From: Amanda Scholes on behalf of Planning.Responses
Sent: 10 January 2019 09:07
To: Planning Scanning
Subject: FW: K/40/18/PL - Demolition of existing dwelling & erection of 1 No. dwelling, associated landscaping & parking (resubmission following K/11/16/PL)
Attachments: Plans Index Sheet_Spring Tide.pdf

Re: K/40/18/PL - Demolition of existing dwelling & erection of 1 No. dwelling, associated landscaping & parking (resubmission following K/11/16/PL)

I have therefore attached the following revised drawings that I kindly ask if you could substitute for the previous versions:

Drawing: Proposed Garage Elevations
Dwg No: 247-D-15

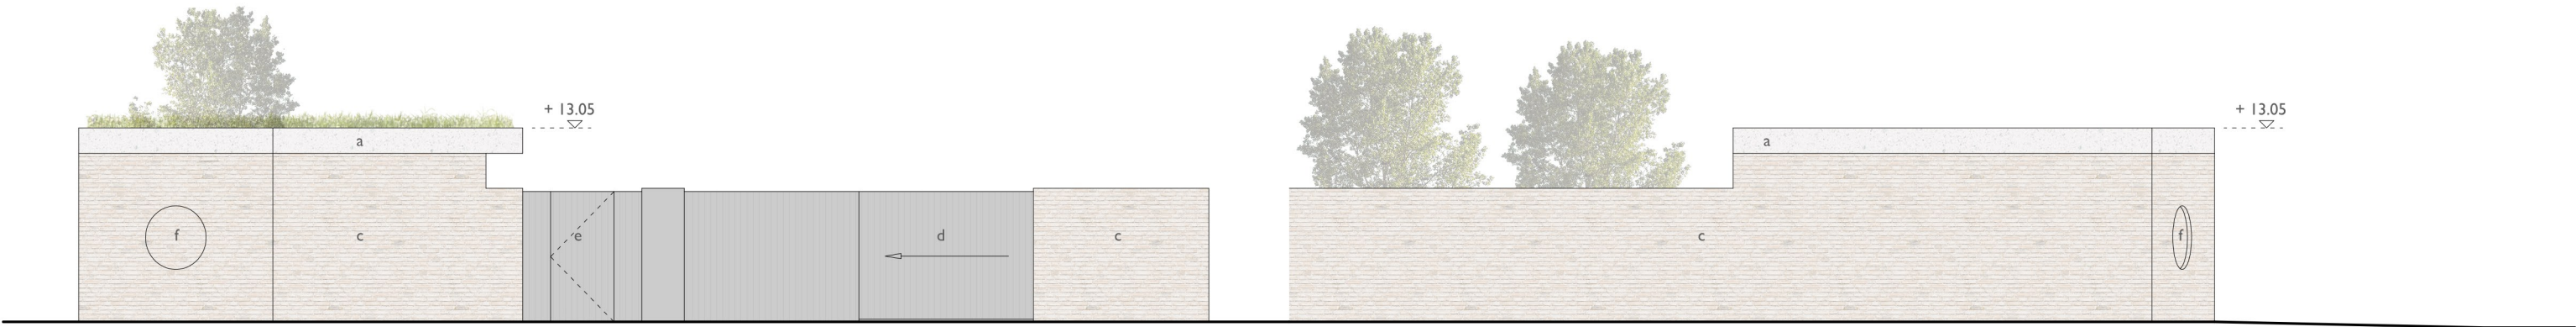
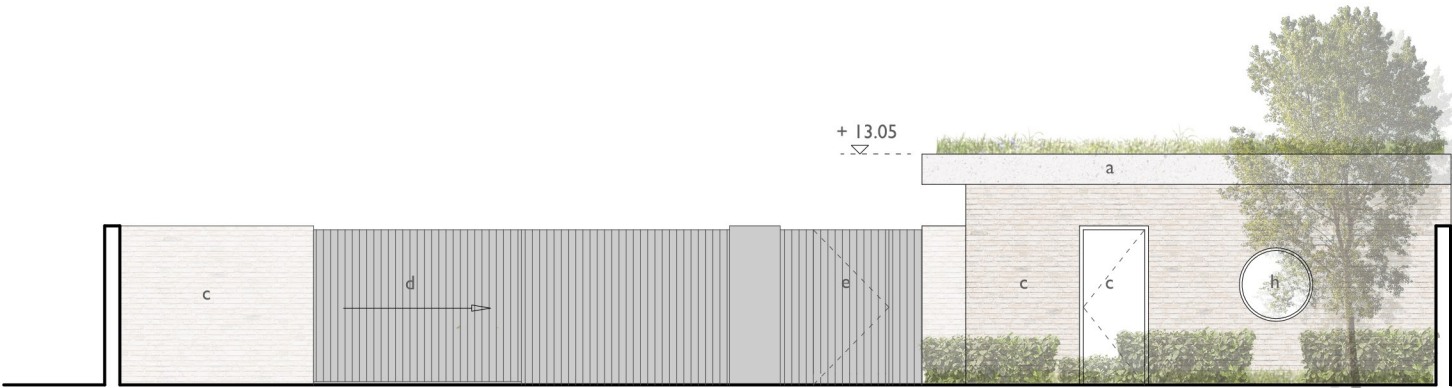
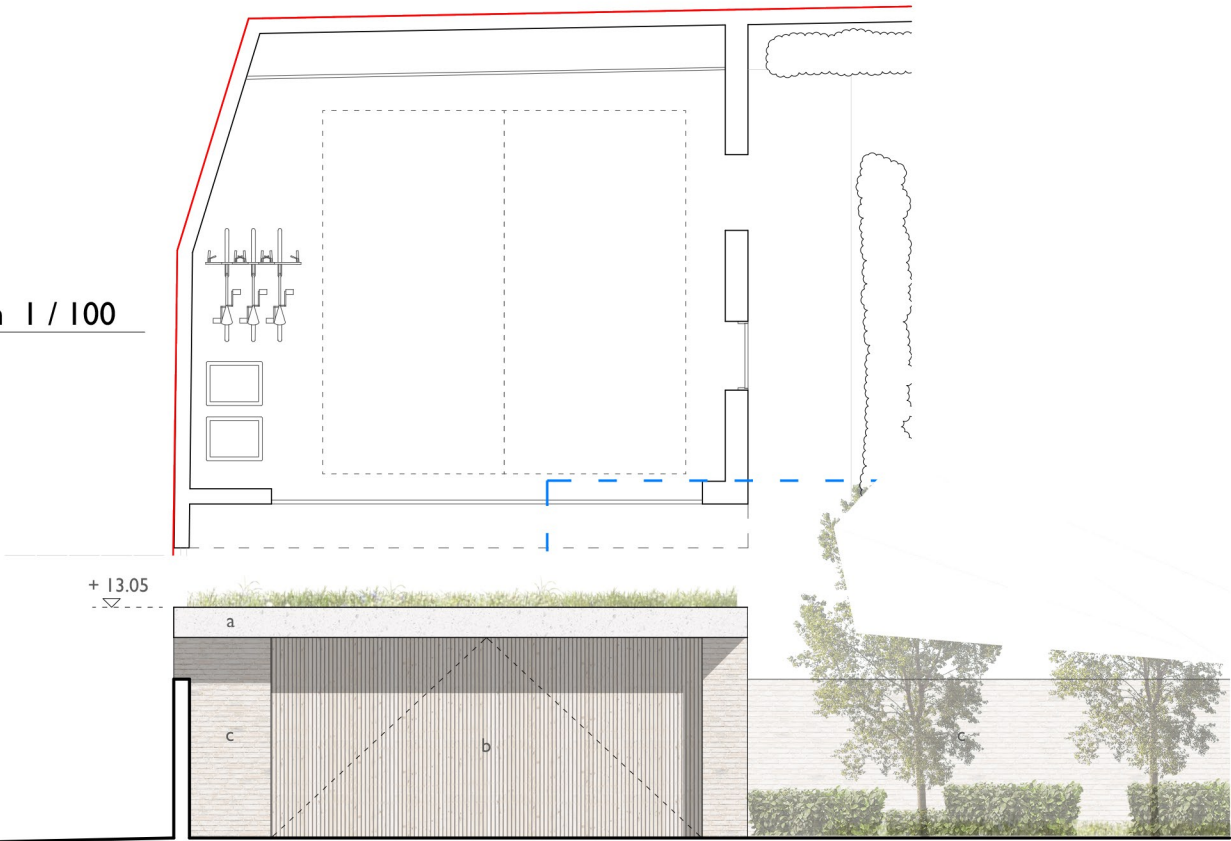
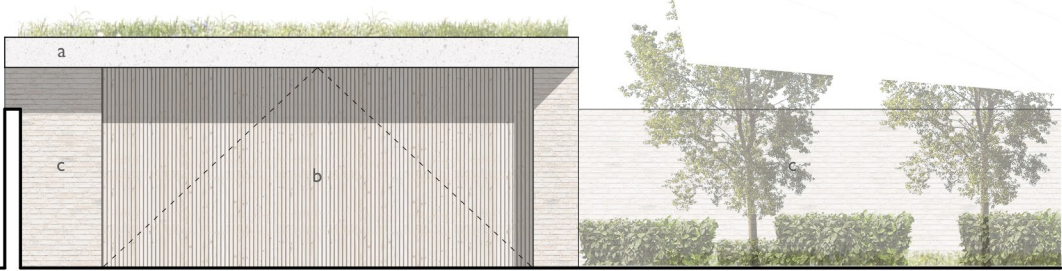
The Board have requested that we remove the detached garage to the front of the plot and that we make the North facing window to the 2nd floor obscured.

I can confirm that 247-D-15 is to be omitted from the application. Please find attached an updated index sheet with all of the updated application drawings

I will substitute these plans for the originals. Please can you also confirm that drawing 247-D-15 is to be deleted from the application and provide a new plans index sheet

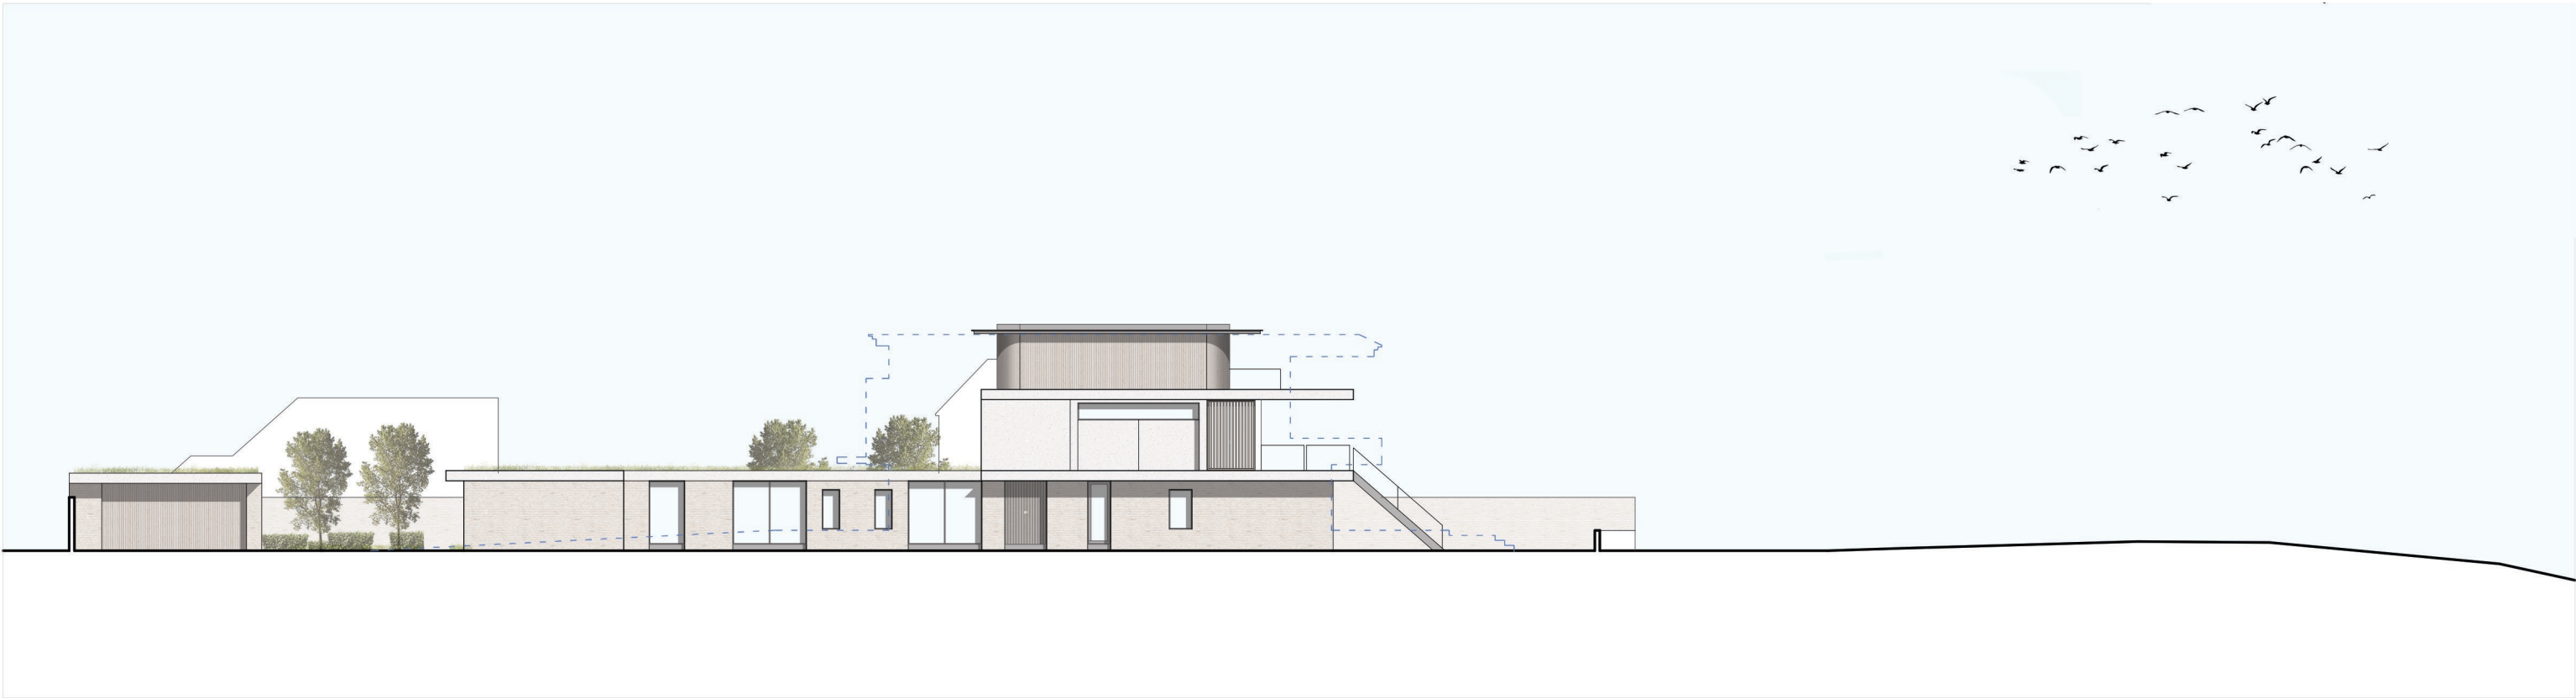
The proposal is only ever so slightly higher than the existing house and just marginally higher (100mm) than the 2018 permission for a new dwelling but it is **significantly** less impactful than the 2018 permission because of the shallow depth of the upper storeys (see attached application drawing D-17). This means that the impact of the proposal on the garden of *Mariners* will be very limited, in particular when compared to the extant permission. Indeed because of the siting of the main part of the building over the footprint of the existing house, there will be very little change from any shadowing that occurs at present.

Drawing: Proposed North Elevation
Dwg No: 247-D-12-REV-A

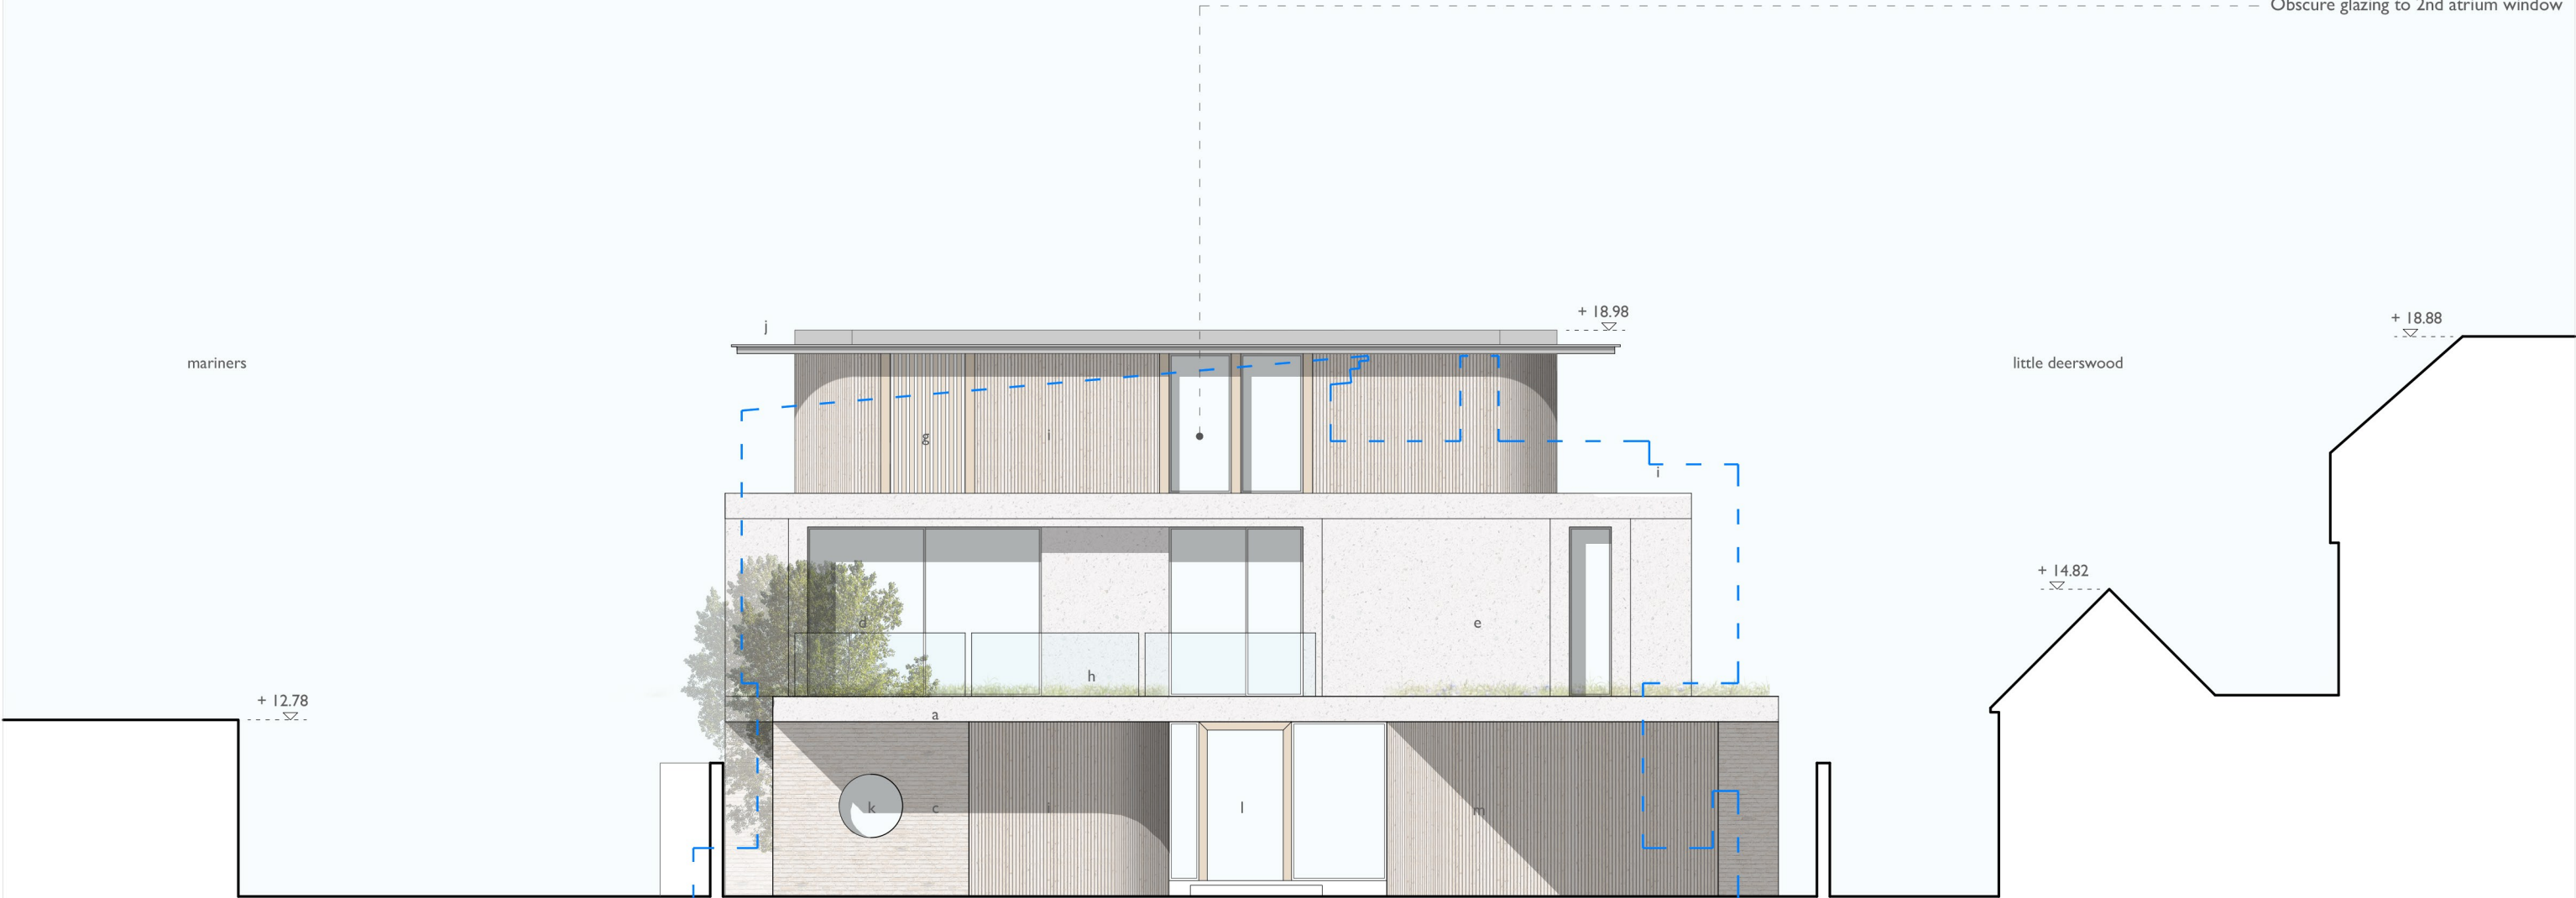
The window at 2nd floor looking to the North over Gorse Avenue is set a full 30m away from the property *Westwood*, and as we discussed on site, the views out from this window are limited as it opens out from an atrium space. However should there be a concern with the impact of this window on the houses to the North, we would be pleased to propose this as obscure glazing.

- D-00 Rev A (Site Location and Block Plan)
- D-02 Rev A (Proposed Site Plan)
- D-12 Rev A (Proposed North Elevation)
